Subject: Rezoning Petition Review

Rezoning Petition #: 23-140

Location of Property: Approximately 7.07 acre site located on the southwest corner of the intersection of Thomas Road and Zoar Road

RZ1.0

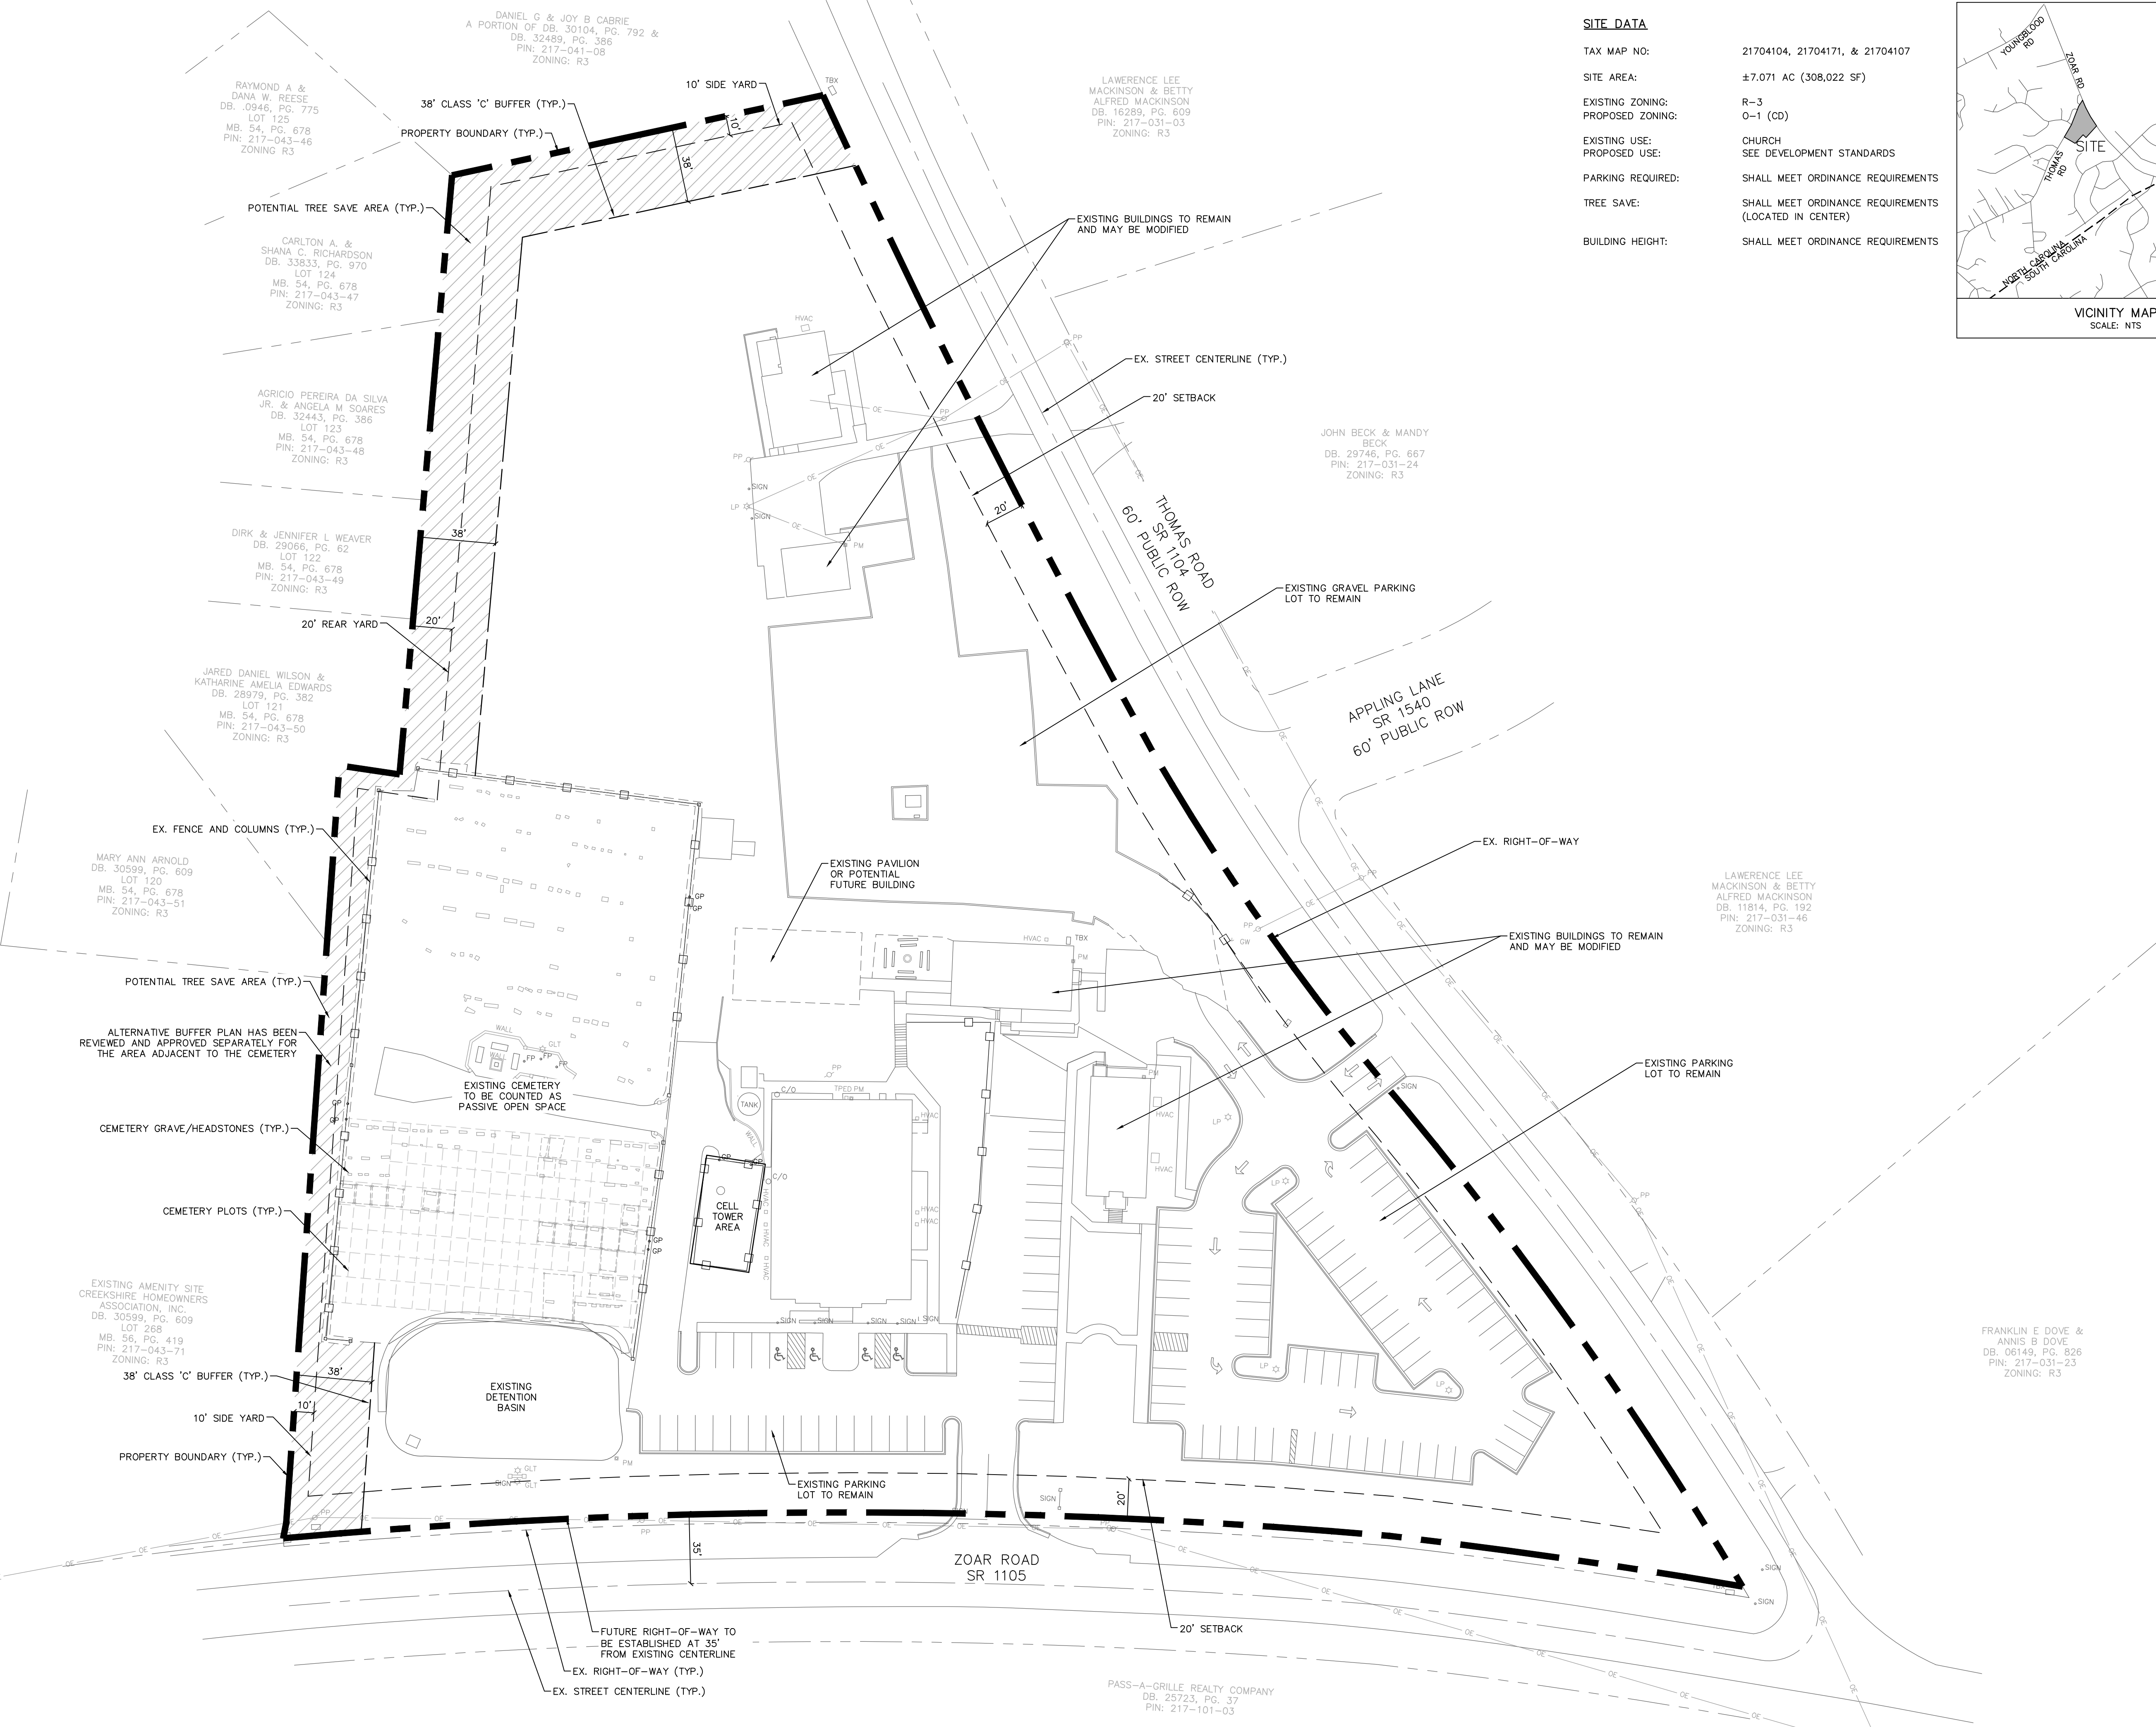
Sheet RZ1.00 indicates an existing detention pond on this site. Please add the following note under section 10, "Storm Drainage" to the plan sheet: If the petitioner utilizes the existing detention pond on site for storm water management requirements of the proposed development, the Petitioner shall include documentation in the formal plan submittal for permitting confirming the proper easements have been established per City standards and that the pond was properly designed and constructed to manage storm water runoff from all parcels served by the pond.

Note 1 under "Storm Water Management" indicates the use of existing Stormwater Control Measures (SCMs) on site to meet applicable ordinances. The use of existing SCMs is not approved through the rezoning process and is part of the formal plan submittal and review process. The request to use existing SCMs shall require proper documentation to confirm proper easements have been established and such SCMs were designed and constructed to manage storm water runoff from all parcels serviced by the SCM

Please include the following notes under "Environmental Features:" The petitioner shall comply with the Charlotte City Council approved and adopted Post Construction Stormwater Ordinance. The location, size, and type of storm water management systems depicted on the Rezoning Plan are subject to review and approval as part of the full development plan submittal and are not implicitly approved with this rezoning. Adjustments may be necessary in order to accommodate actual storm water treatment requirements and natural site discharge points.
